From: Adam Shephard [REDACTED]
Sent: 11 April 2019 16:10
To: David Innes; Laura Gibbons; Andrew Wood
Cc: Christian O'Brien; Rob Wilson; James Bragg
Subject: RE: Windroos, Littlehampton

Please see attached the updated drainage layout plan and calcs. The updates include the following in order to address the comments:

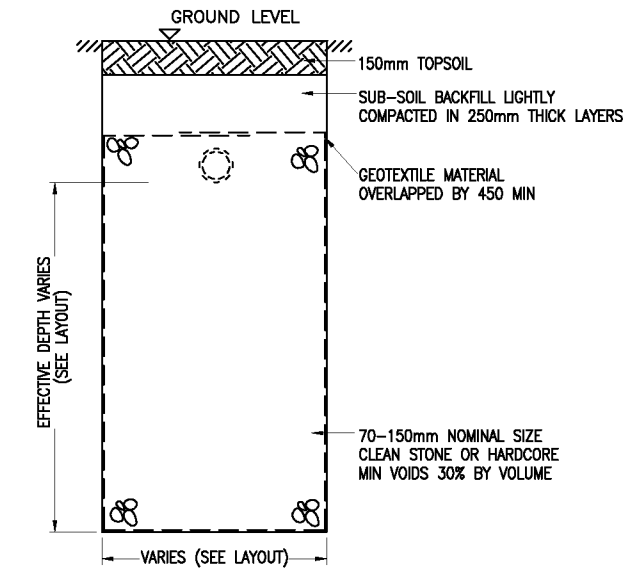
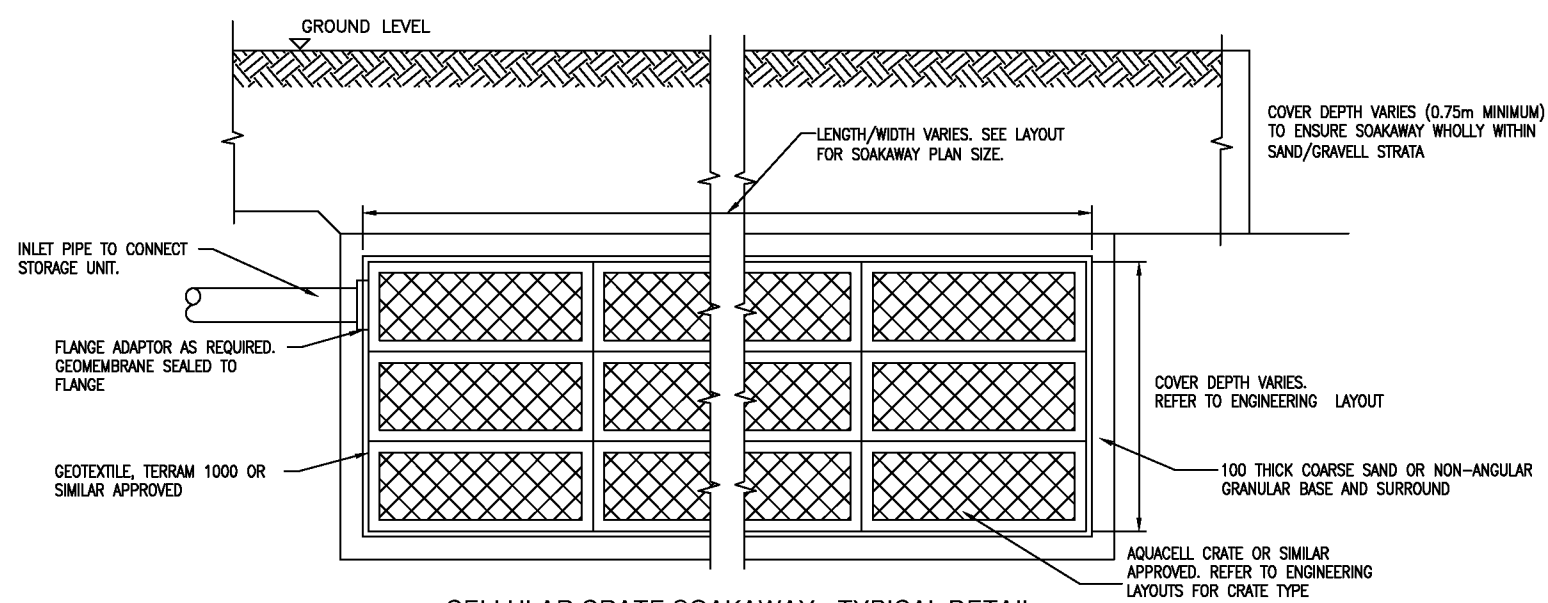
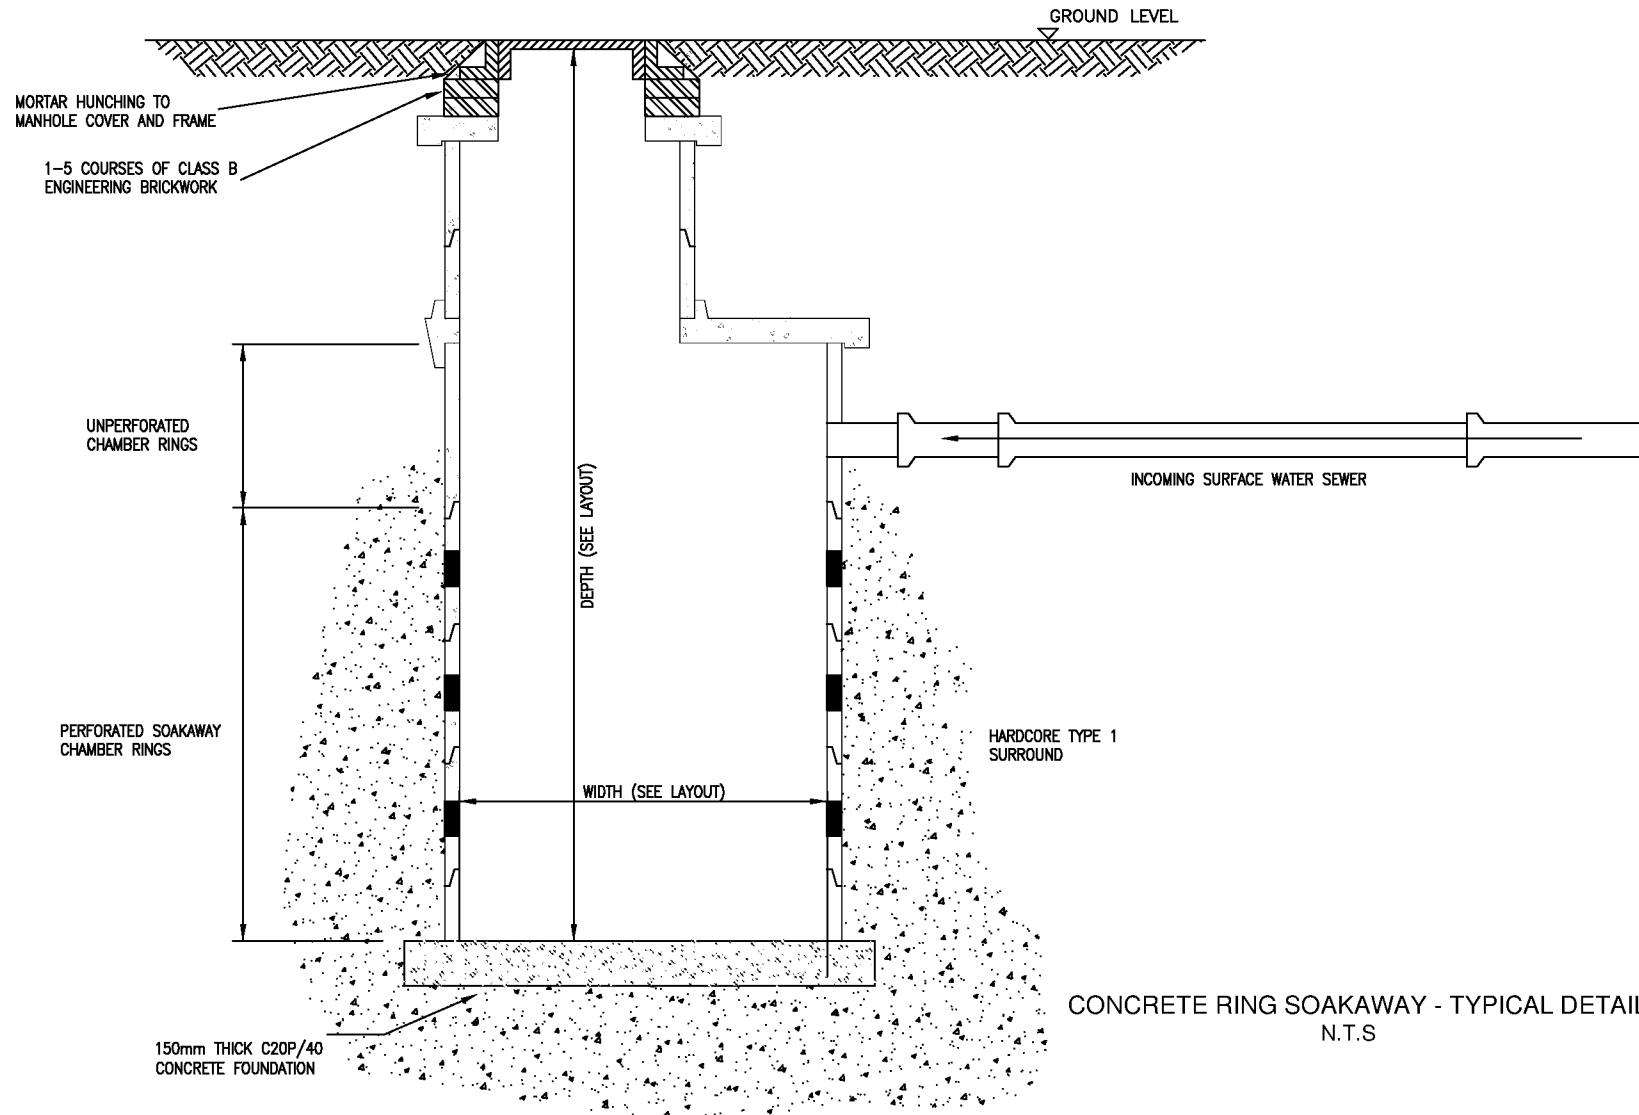
6. The ring soakaways are proposed to be located at 2m depth, yet rely on infiltration testing completed at 4.2m depth. The strata at these depths differs significantly. Again I stress the importance of completing winter infiltration testing at the proposed depth and location of infiltrating structures. We have provided a calculation for the specification of a ring soakaways at 3.6m depth with a 2.4m diameter, which is in the appropriate strata. The latter part of this point relates to the responses to points 1 and 2.

- Changing the ring soakaway size to 2.4mØ x 3.6m dp which addresses the comment from about suitability of the strata. This is adequate in terms of modelling which is also attached.
- Updating the trench soakaway references to have specific numbering which tie in with the attached modelling outputs from Microdrainage for them

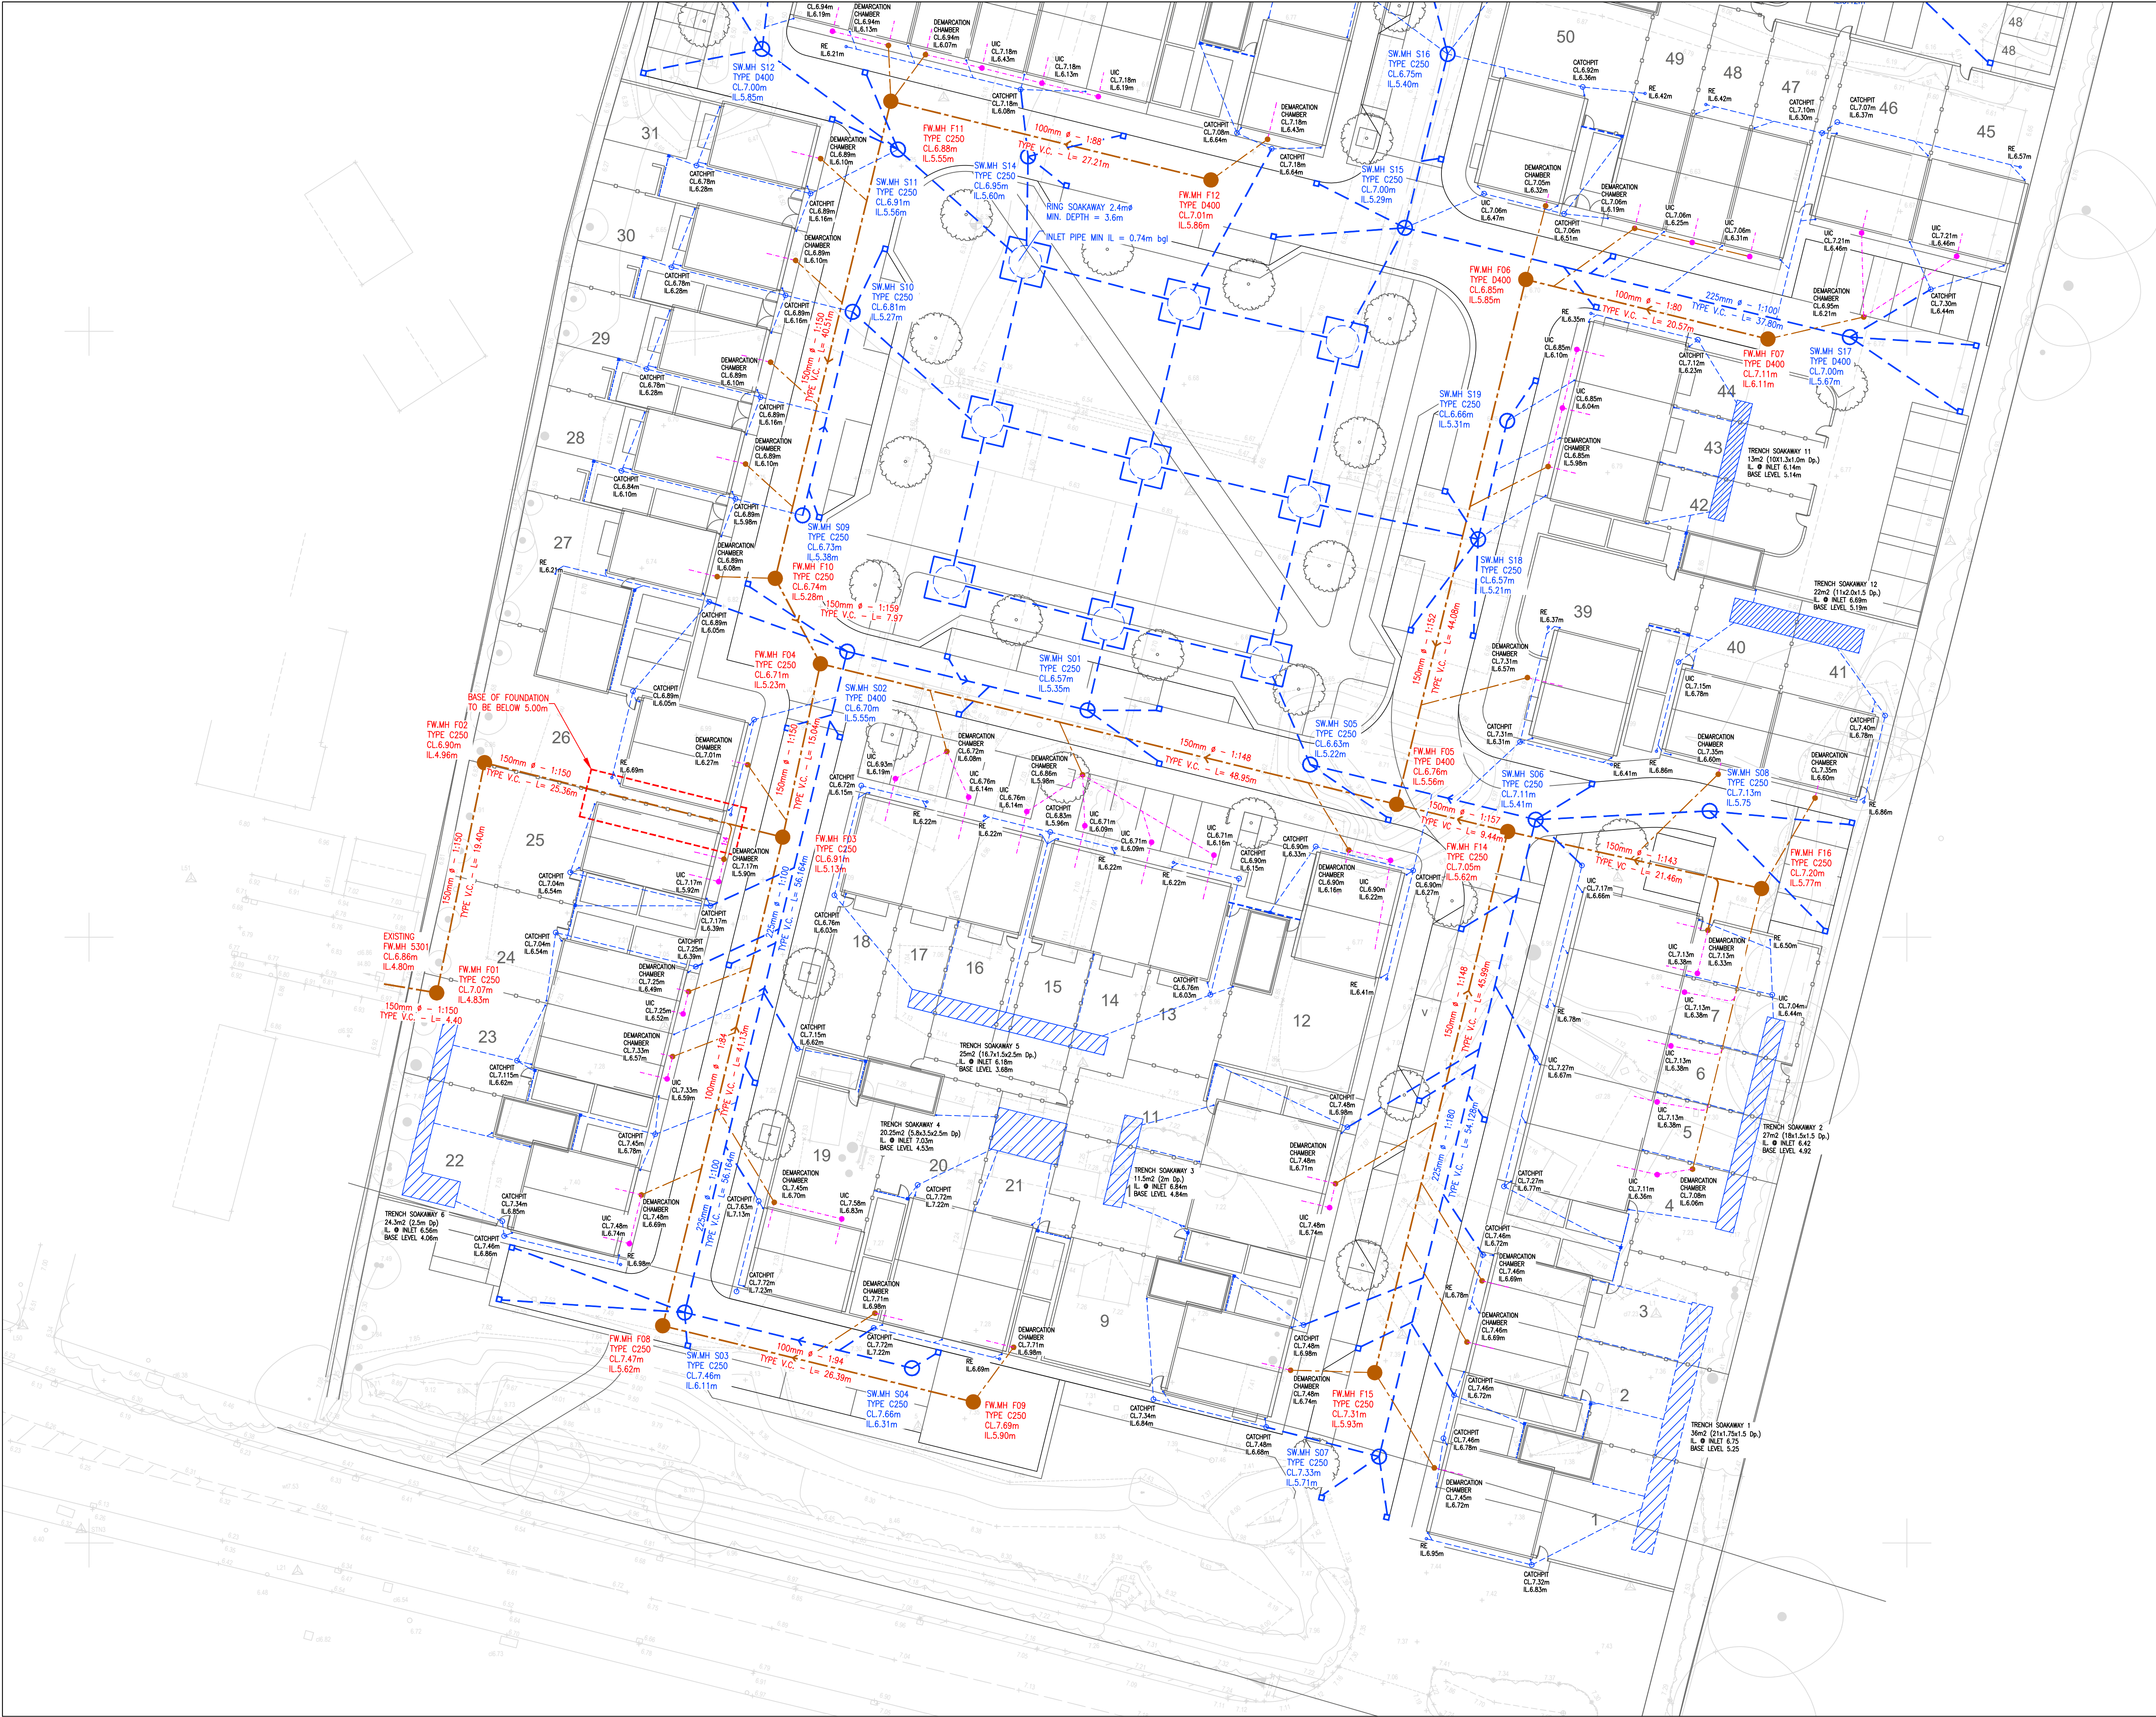
5. One of the sets of calculations provided does not seem to equate to anything proposed on paper. I.e. the modelled dimensions are not reflected on plan. All the calcs had a reference against the design but hopefully the provision of all of the gravel trench soakaways clears this up.
